SOUTH HOLLAND DISTRICT COUNCIL

To: Planning Committee - 09 October 2019

Application Number: H02-0669-19

Description: Outline application for the erection of up to 6no. self-build eco-homes with access from James Road (Re-submission of H02-0868-17)

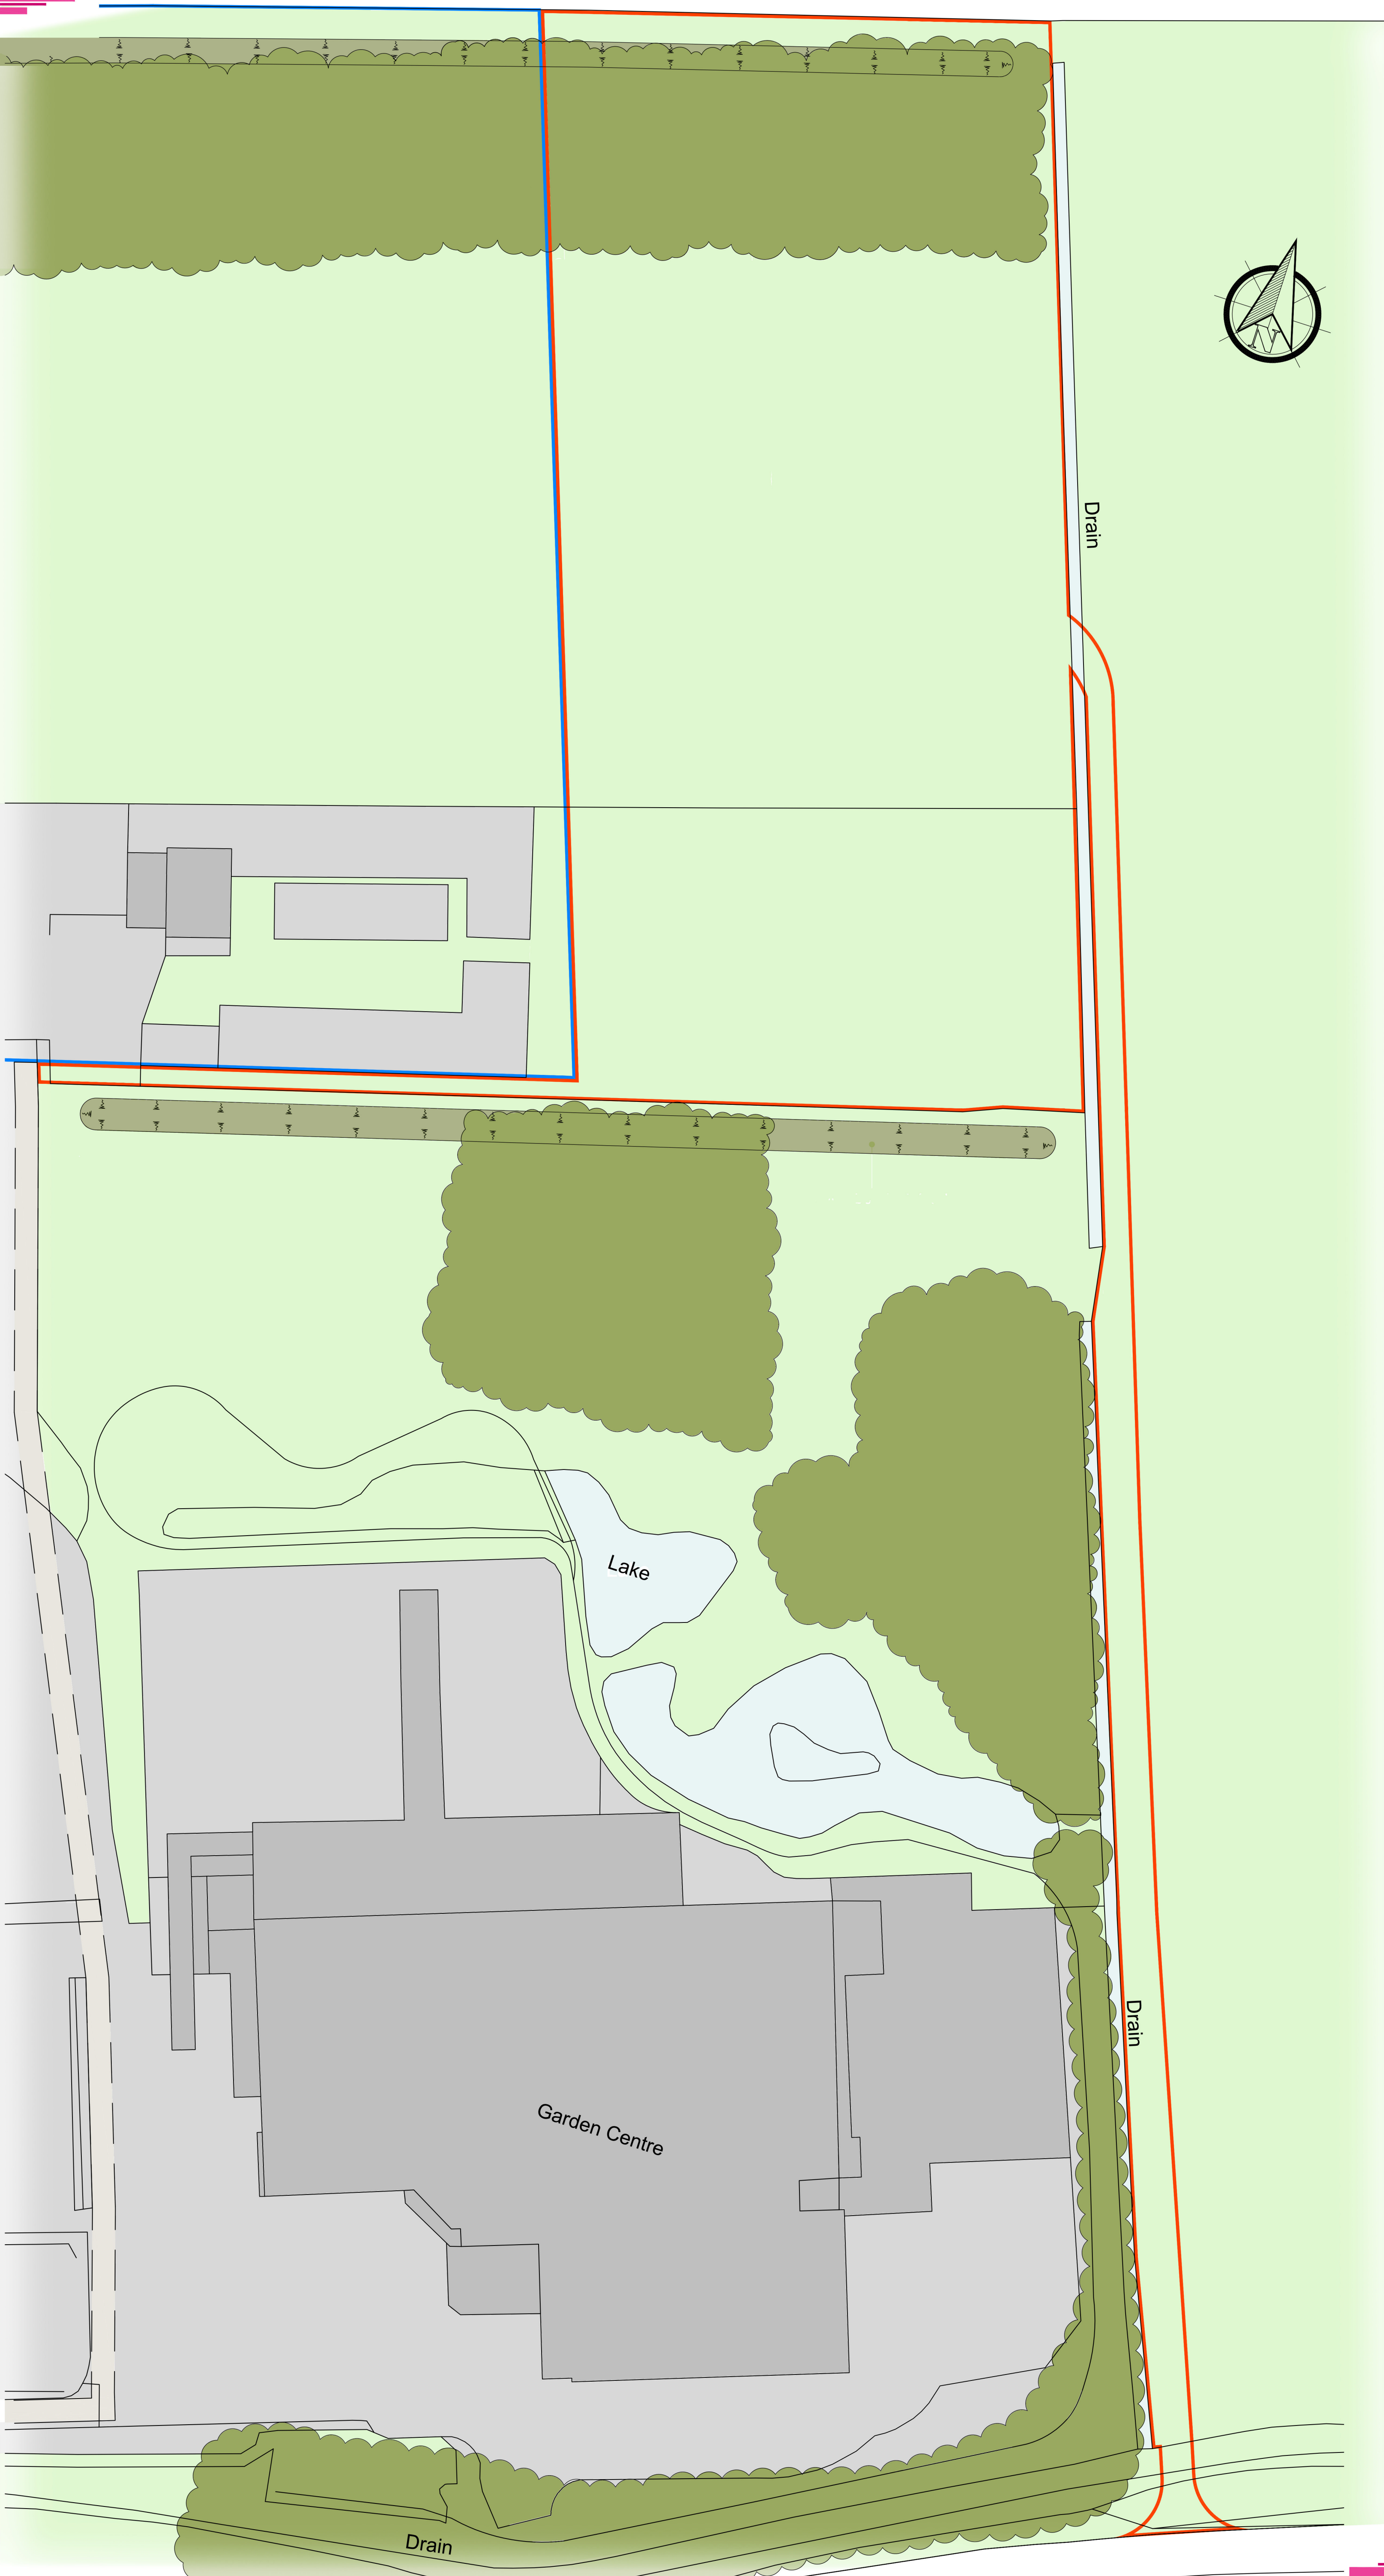
- 7.23 Highway Safety and Pedestrian Access
- 7.24 The site would be accessed via a private drive (approximately 280 metres in length) to the eastern side directly onto James Road. The access would be a 3.7 metre wide single carriageway private drive with widened passing sections every 50 metres.

- 7.25 The private drive would have an impact on the visual character of this part of the open countryside, and would read as a discordant feature, being a road designed to accommodate a residential development and having vision splays, which would create a hard edge to this part of the countryside.

- 7.26 The application also seeks to include a new pedestrian footpath to the south-west of the site linking to an existing 3.6 metres wide right of way providing pedestrian access from the site to the public footpath on Postland Road. The footpath, as outlined, is approximately 145 metres in length. The right of way is a further 310 metres.

- 7.27 Whilst it is not contended that there is a right of way between the site and Postland Road (the on-going public footpath), the proposal involves walking a significant distance across access roads to the adjacent garden centre and caravan businesses. This is considered to be a

contrived solution that results in a poorly integrated development site from a pedestrian access point of view. Whilst this may not raise a highway objection from a safety perspective, the solution is considered to contribute to concerns over the relationship between the development site and the existing built-up residential area of Crowland.
